# Rampion 2 Wind Farm

## Statement of Common Ground – Historic England

**Date August 2024**  
**Rev G**

Examination Reference: 8.7  
Pursuant to: Infrastructure Planning (Examination Procedure)  
Rules 2010, Rule (8)(c)  
Ecodoc number: 005114184-01

Figure 1-6: Preliminary recommendations for geoaerchaeological core locations

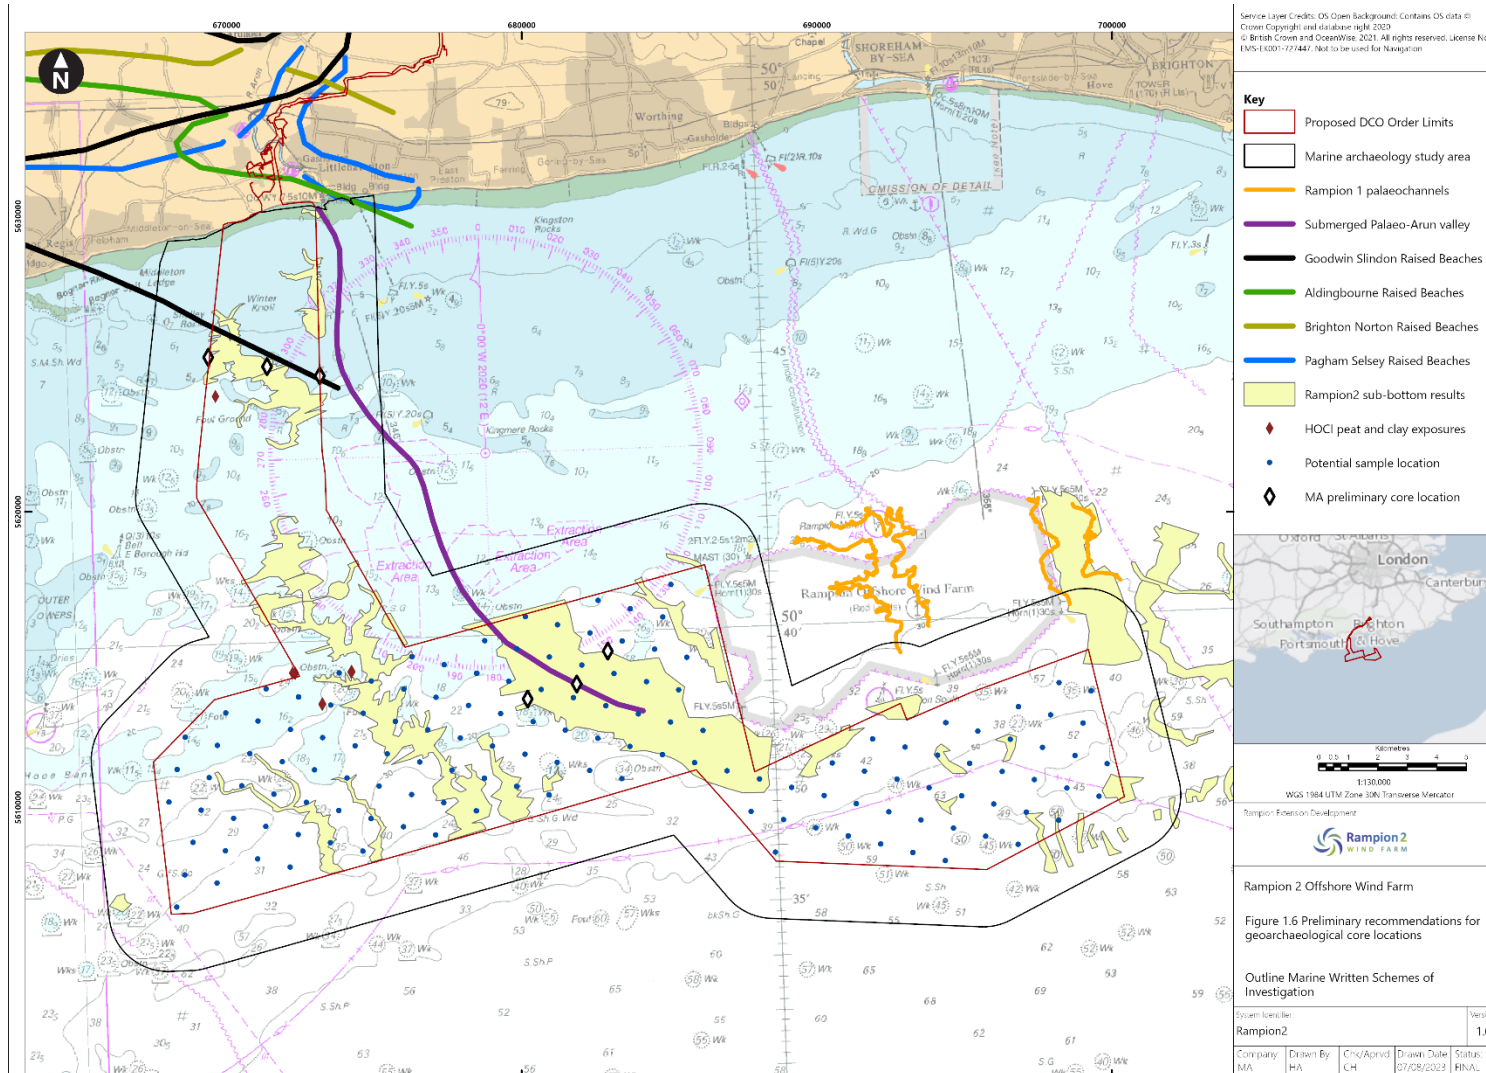
Reference Number	Matter of Contention	Historic England’s Position	Applicant’s Position	Current Status	Date of Agreement	Notes
HE4	Limitations of marine archaeology evaluation	<p><b>Concerns</b></p> <p>Historic England is aware that marine geophysical survey was undertaken in 2020 and in 2021 and Historic England concur with the Applicant that there is the possibility that presently unidentified marine heritage receptors might be discovered within the proposed DCO Order Limits which could be impacted directly or indirectly by the proposed development.</p> <p><b>Desired Actions</b></p> <p>The Outline Written Schemes of Investigation (WSI) should provide for geoarchaeological analysis of geotechnical survey materials.</p>	<p>This was discussed during the Evidence Plan Process. The Applicant declared that no geotechnical cores would be collected before the decision on development consent is granted. However, all available information will be used to ensure that the Final WSI and embedded environmental measures clearly state that archaeological input must be sought ahead of geotechnical campaigns (in accordance with C-59). The Applicant responded to this at Deadline 2 as part of the Applicant’s Response to Prescribed Consultee [ <b>REP2-026</b>] (Reference: 11.27).</p> <p>Future geoarchaeological assessments will be undertaken using a staged geoarchaeological approach to assessment and analysis of the collected geotechnical data resulting in project reports and a deposit model. The assessments will be used to contribute to seabed mapping and modelling of submerged prehistoric landscapes, resulting in a greater understanding of the prehistoric past and the use and habitation of submerged former terrestrial landscapes. Preliminary, recommended archaeological core locations, based on the 2020 sub-bottom data and desk-based</p>	Agreed	01/08/24	<p>01/08/24: HE are prepared to agree given submission of a revised Outline Marine Written Scheme of Investigation at Deadline 5 (PINs Ref: REP5-076 ‘clean’ &amp; REP5-077 ‘tracked’) and which followed HE advice submitted previously, such as more attention now given to geoarchaeological aspect</p> <p>09/07/24: Advised on the 3<sup>rd</sup> of June 2024 clarified that should consent be obtained, a suitable WSI shall be produced in consultation with Historic England, in accordance with any Deemed Marine Licence, and thereby allow for subsequent survey method statements to be produced in consultation with Historic England.</p> <p>The Applicant acknowledges that all future Method Statements outlining geotechnical works will be produced in consultation with Historic England.</p> <p>Details on the methodical approach to sample collection and subsequent geoarchaeological</p>

Reference Number	Matter of Contention	Historic England's Position	Applicant's Position	Current Status	Date of Agreement	Notes
			<p>data can be seen in Figure 1-6, <b>Outline Marine Written Schemes of Investigation, [APP-235]</b> (updated at Deadline 3).</p>			<p>assessment has been added to the <b>Outline Marine Written Schemes of Investigation, [APP-235]</b> (updated at Deadline 5).</p> <p>An updated <b>Outline Marine Written Scheme of Investigation [REP3-041]</b> has been submitted at Deadline 5 to address concerns raised by Historic England in 'Comments on any further information/submissions received by Deadline 3' <b>[REP4-087]</b> (submitted at Deadline 4). The updates include;</p> <p>Removal of section 5.7.</p> <p>The text "and in consultation with "statutory historic" bodies i.e. Historic England (Generation and Transmission Assets) and West Sussex County Council (Transmission Assets)" has been added to Table 6-4.</p> <p>Section 6.5 has been updated to include possible sample methods (vibrocore and boreholes) as well as a methodical approach to the archaeological assessment of geotechnical cores. Further details have also been added to section 8.4.</p>
